BCA Design Assessment Report

St Joseph's College
Physical Education &
Sports Precinct Project (PESPP)

Project: St Joseph's College Physical Education & Sports Precinct Project
 Document Type: BCA Design Assessment Report
 Report Number: P217_362-2 (BCA) LS

Project
**PHYSICAL EDUCATION AND
SPORTS PRECINCT PROJECT**
Drawing Title
PROPOSED ROOF PLAN

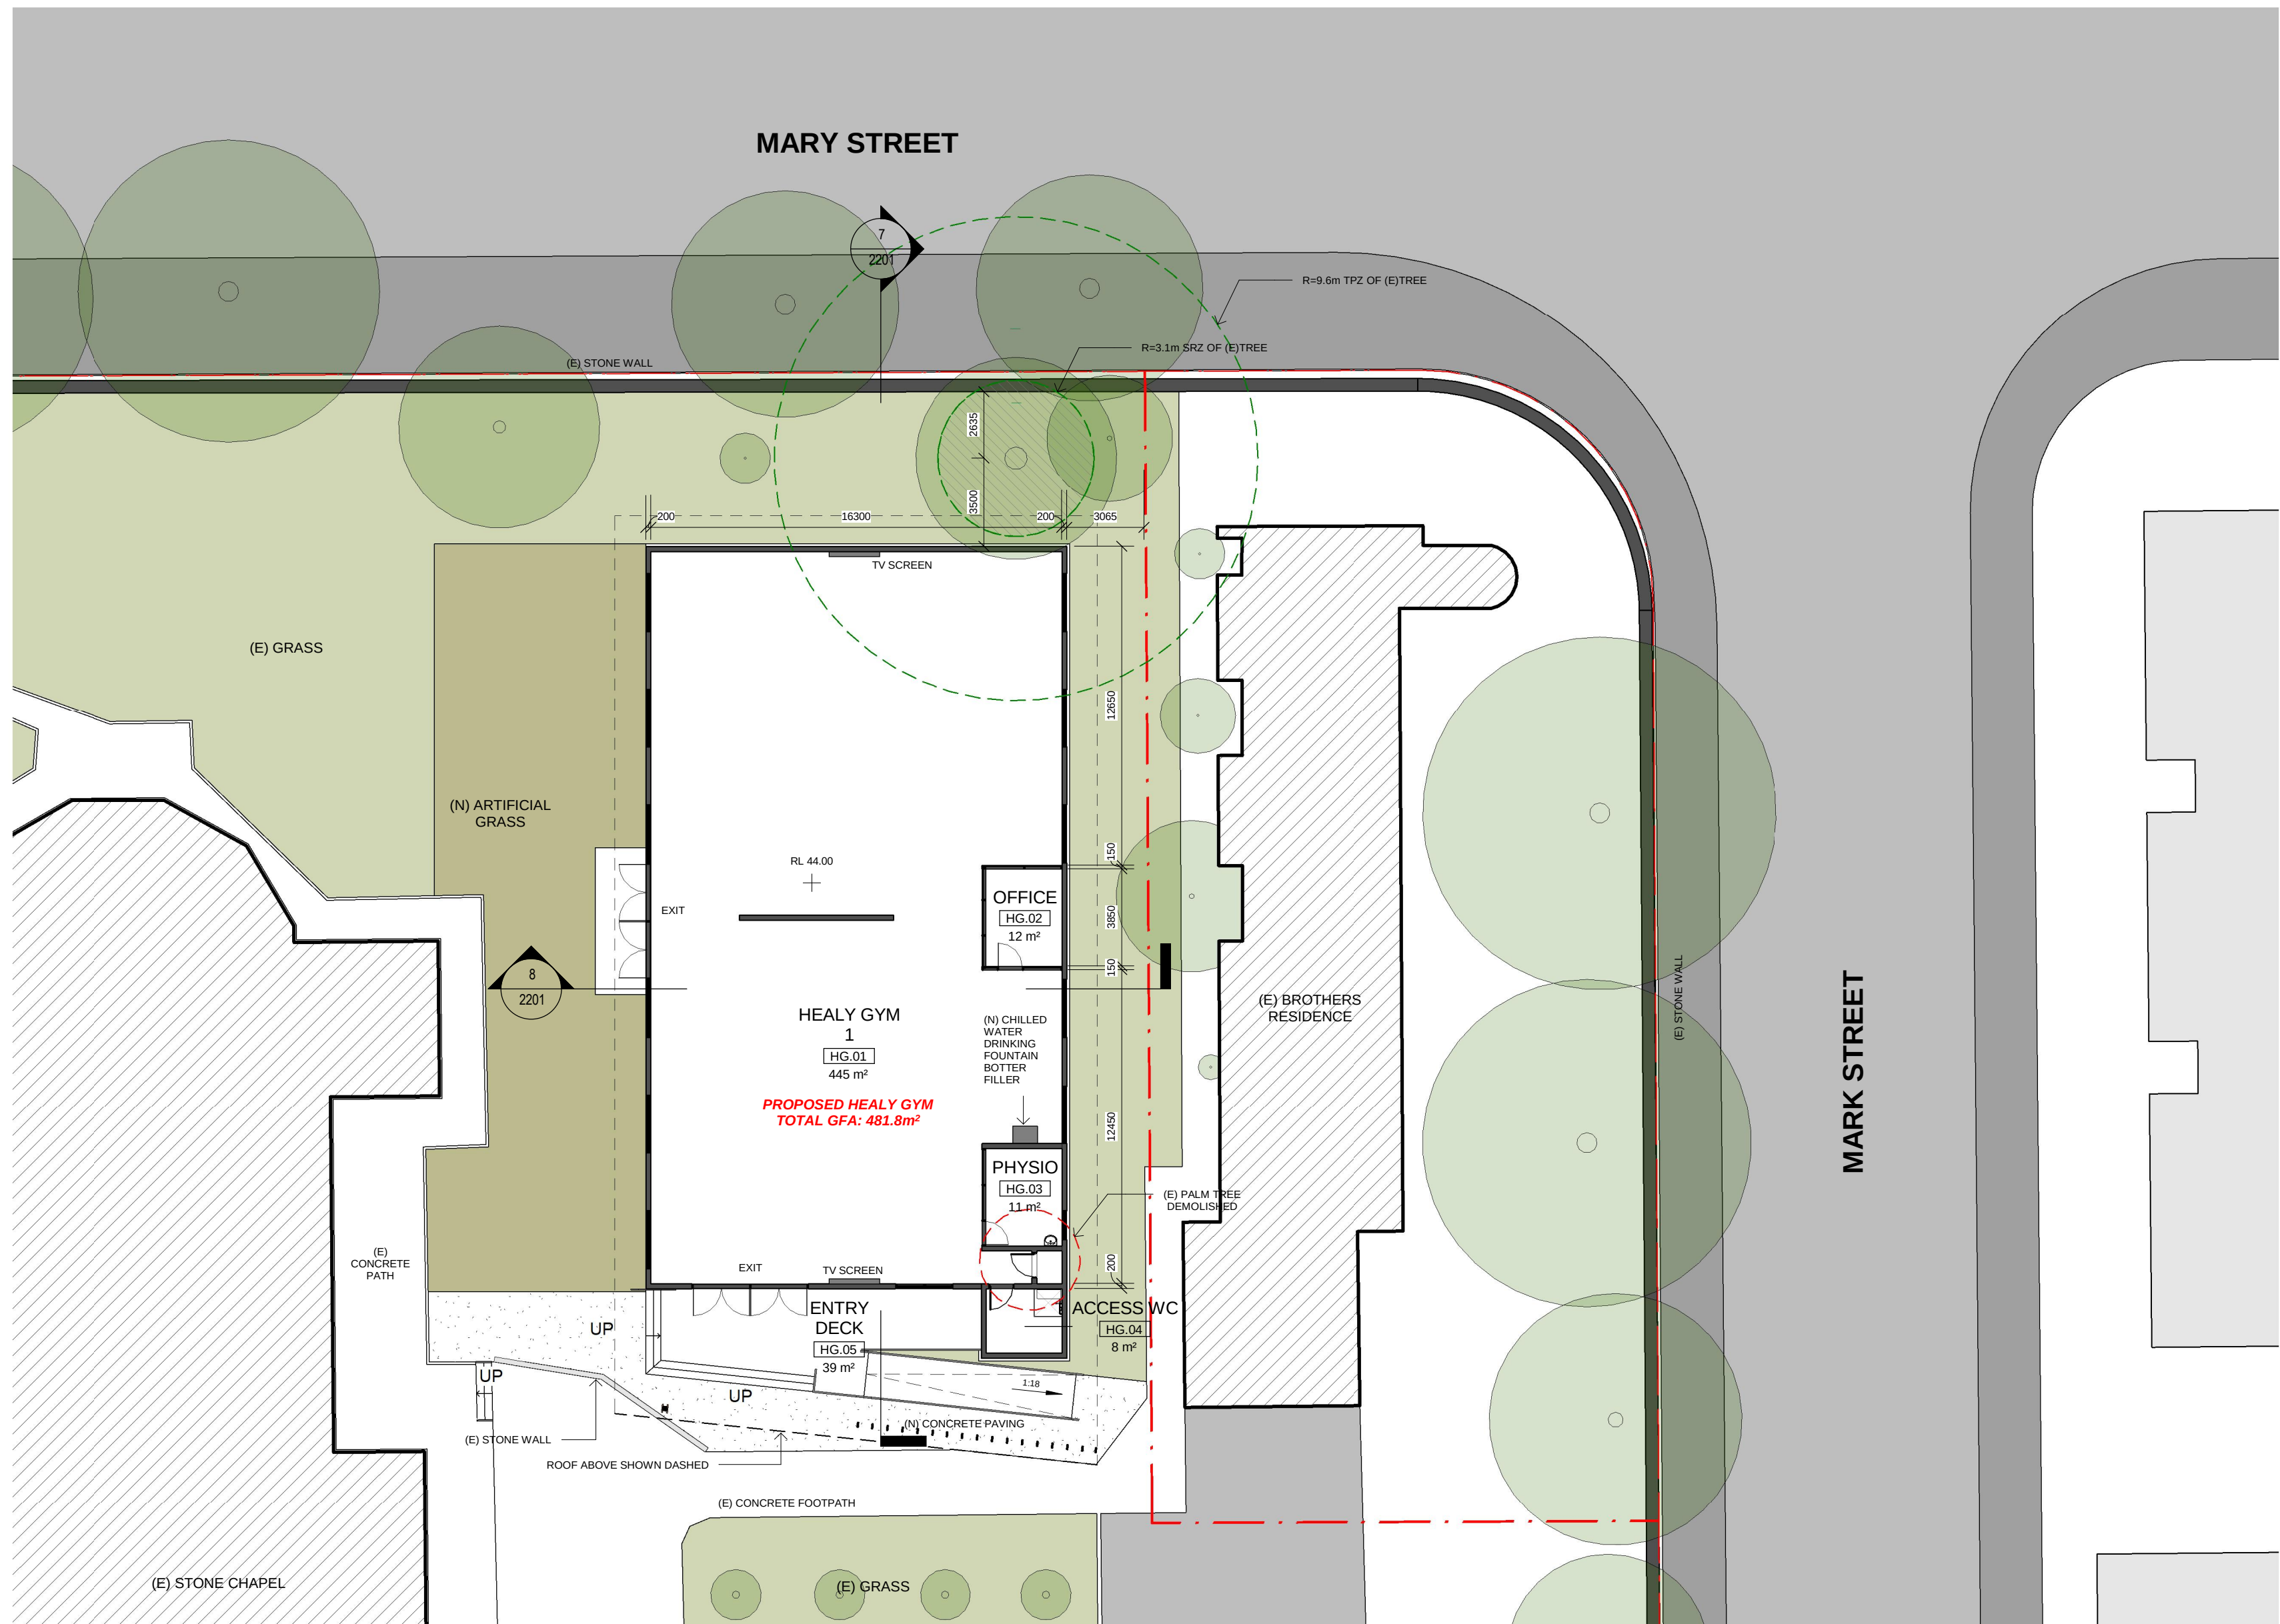
8.	Further co-ordination needs to occur around the plant area / room located on the roof level, specifically the egress arrangements from this space.	All

☐ Roof Plant

The total travel distance from the furthest part of the roof plant level is greater than 20m to an exit (being ~35m);

With respect to the above, the following options for resolution are proposed –

- (i) Modify the roof plant level so that the distance to the exit (i.e. top of stair tread) is less than 20m; or
- (ii) Adopt a performance-based approach justifying that the current design complies with the relevant performance requirements.

1
1101
PROPOSED NORTH ELEVATION
1 : 200

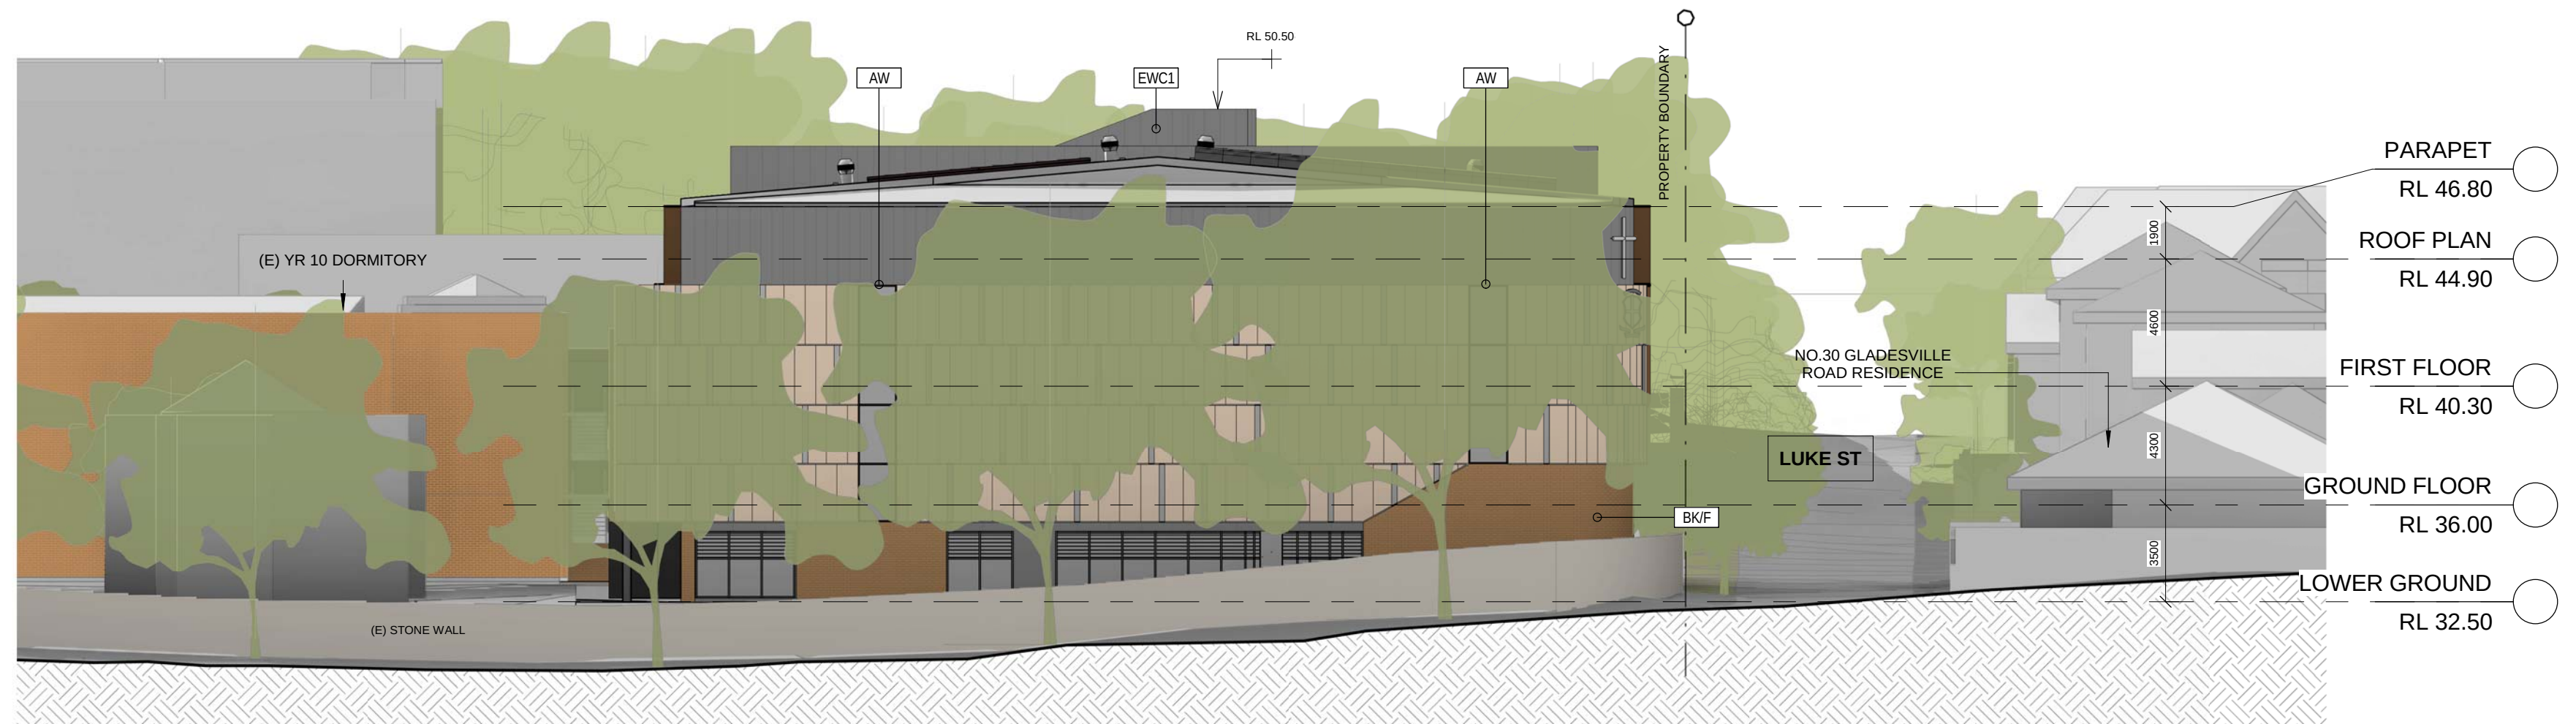
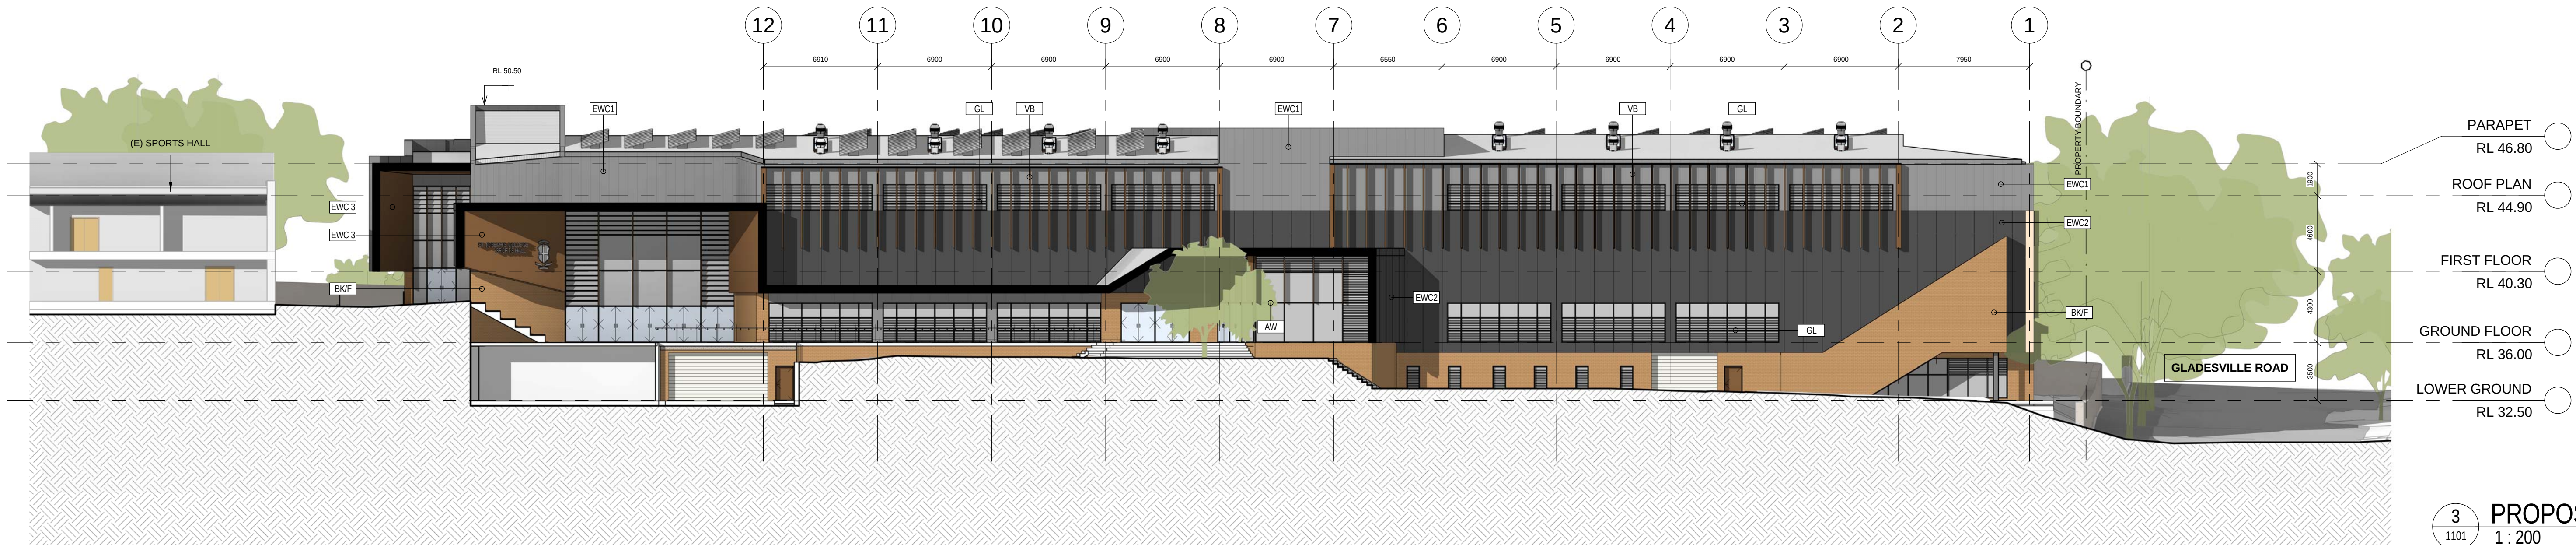
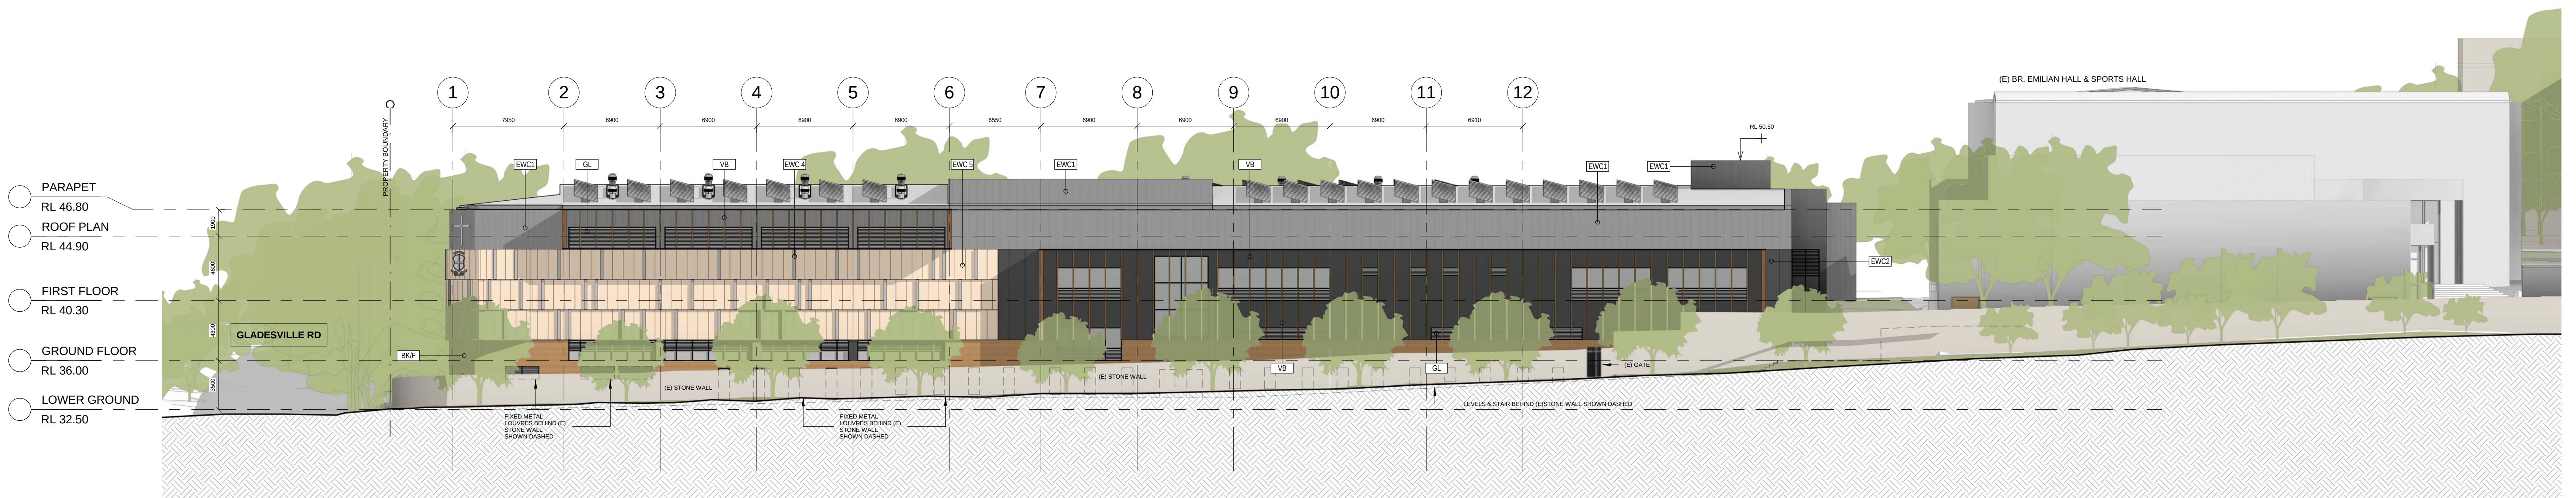
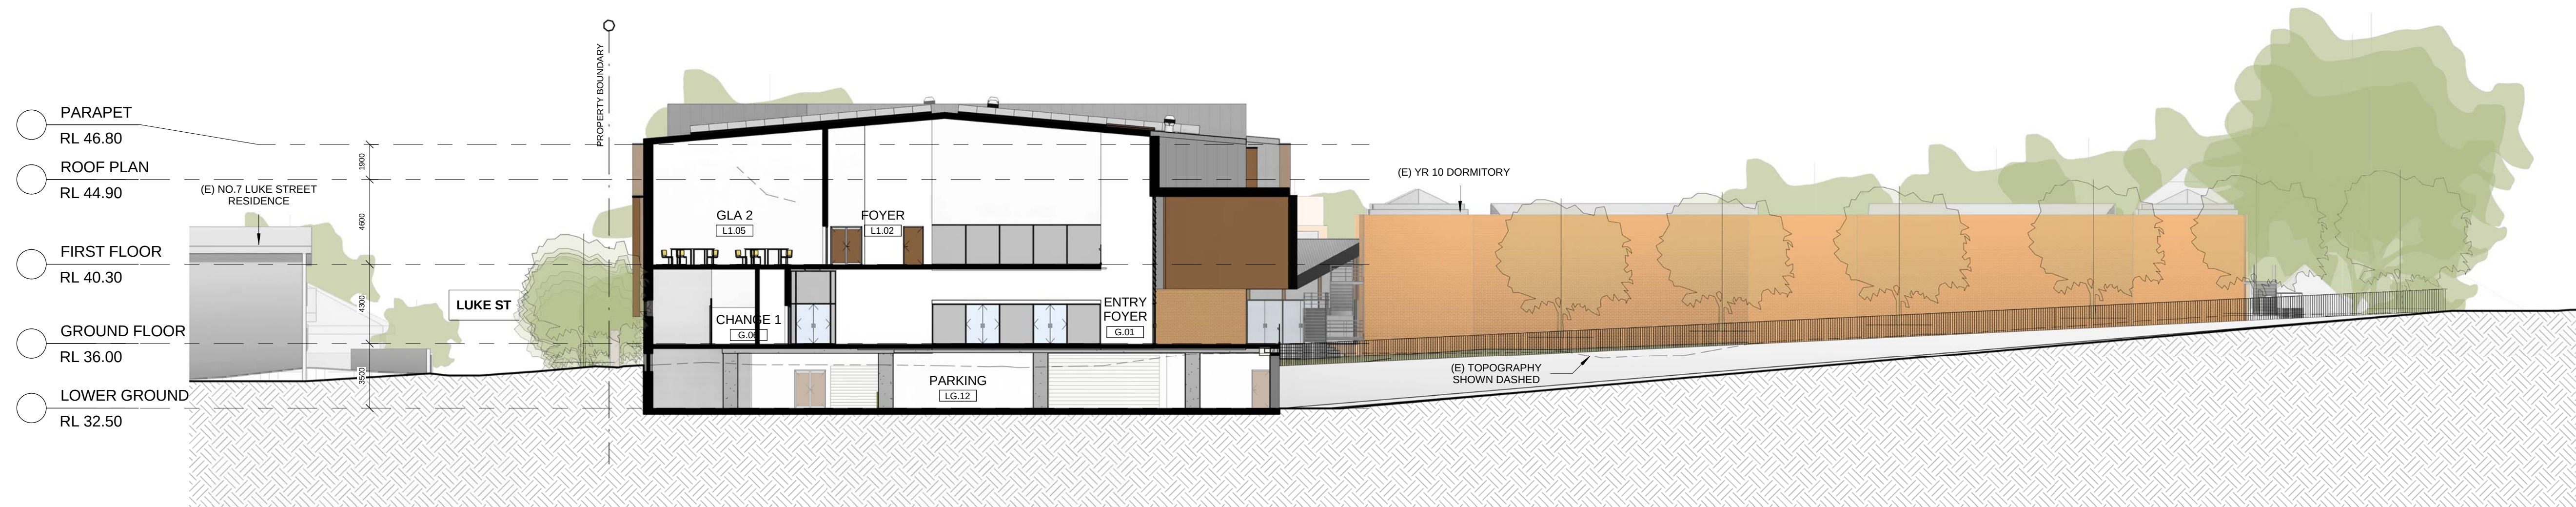
2.	Sections and elevations are to be provided such that we can confirm that both the floor area and volume of the building is within the prescribed limits.	Project Architect
